**Annex 1: Natural England's responses to Examining Authority's initial questions.**

**Question 1.2.13.**

**Ancient Woodland and Veteran Trees**

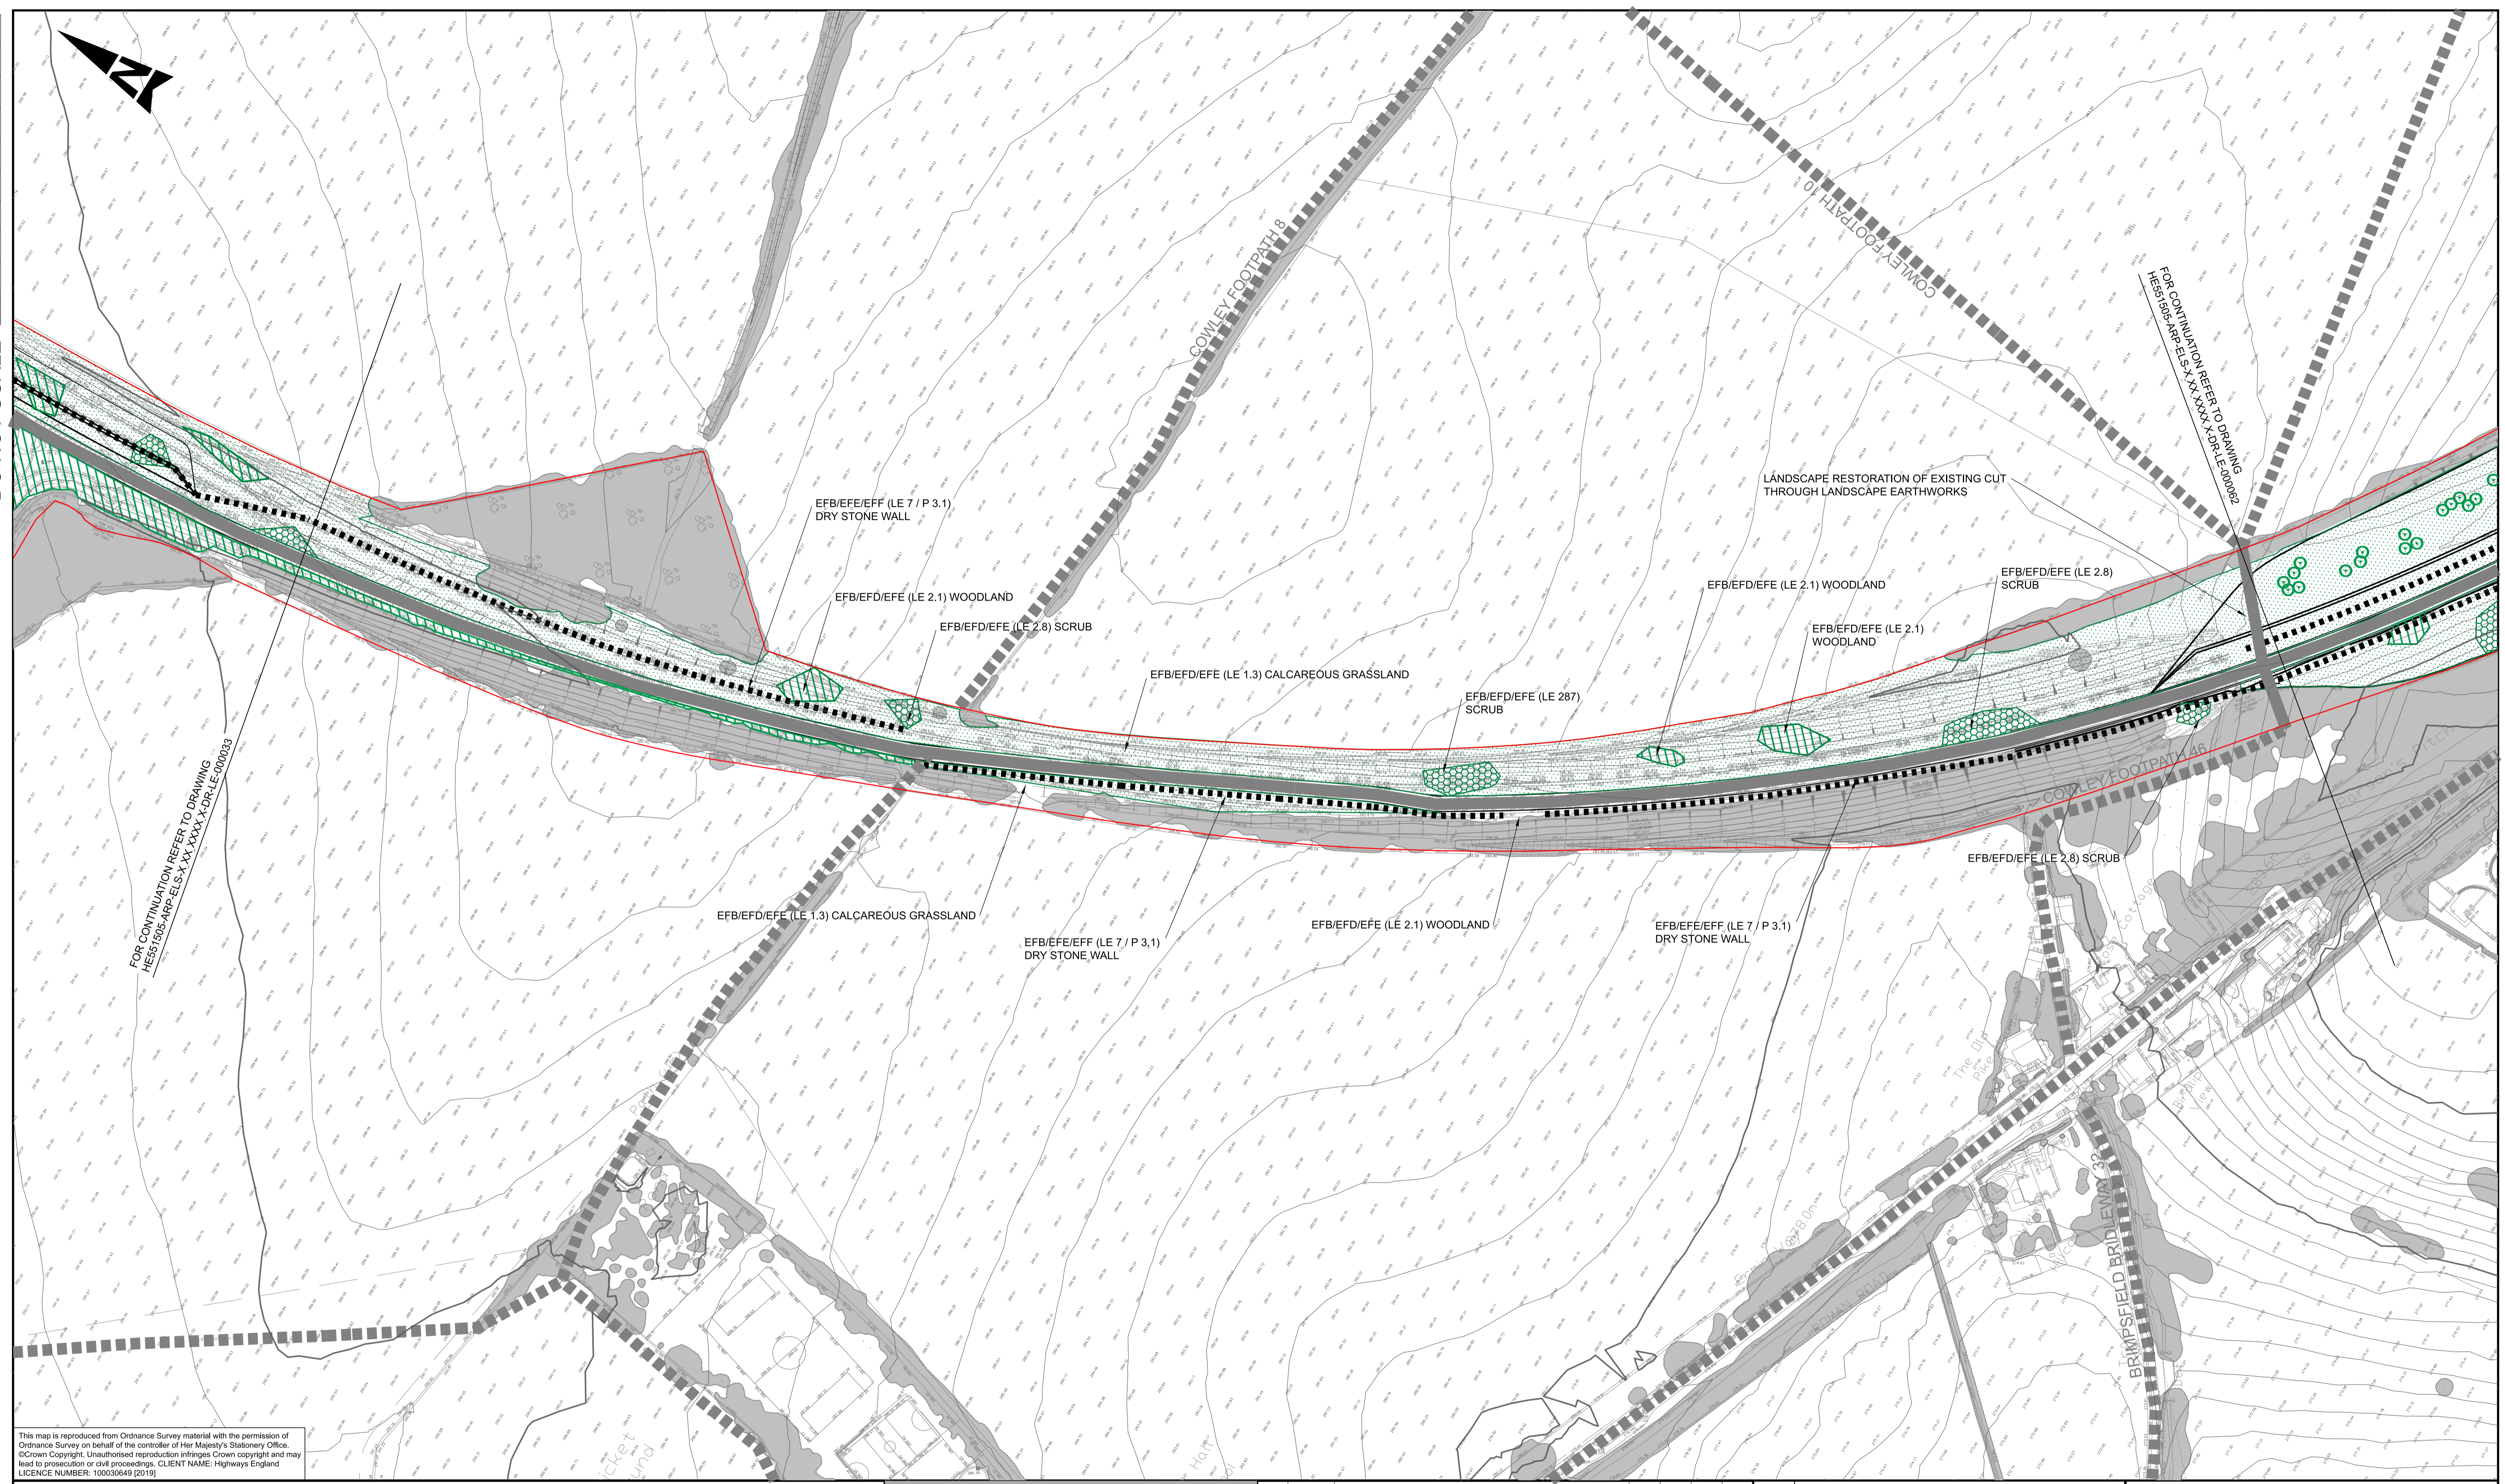
The landscape design for the scheme includes 2.1ha of new woodland planting adjacent to Ullen Wood, in areas that will receive less than 0.4kg N/ha/yr increase as a result of the scheme. This is shown on Figure 7.11 of the Environmental Masterplan (Document Reference 6.3). This compensation is presented as appropriate to this location, taking into account other habitat types in the area such as calcareous grassland. In addition, National Highways will explore opportunities to contribute towards the enhancement of Ullen Wood through improvements to its management.

Natural England accepts that the scheme impacts are unavoidable with this route, that mitigation is not possible, and we therefore accept the principle of compensation, in this specific case. We are satisfied that the compensation proposed is appropriate in the circumstances. This subject is included in our Statement of Common Ground with National Highways, in the 'matters agreed' section.
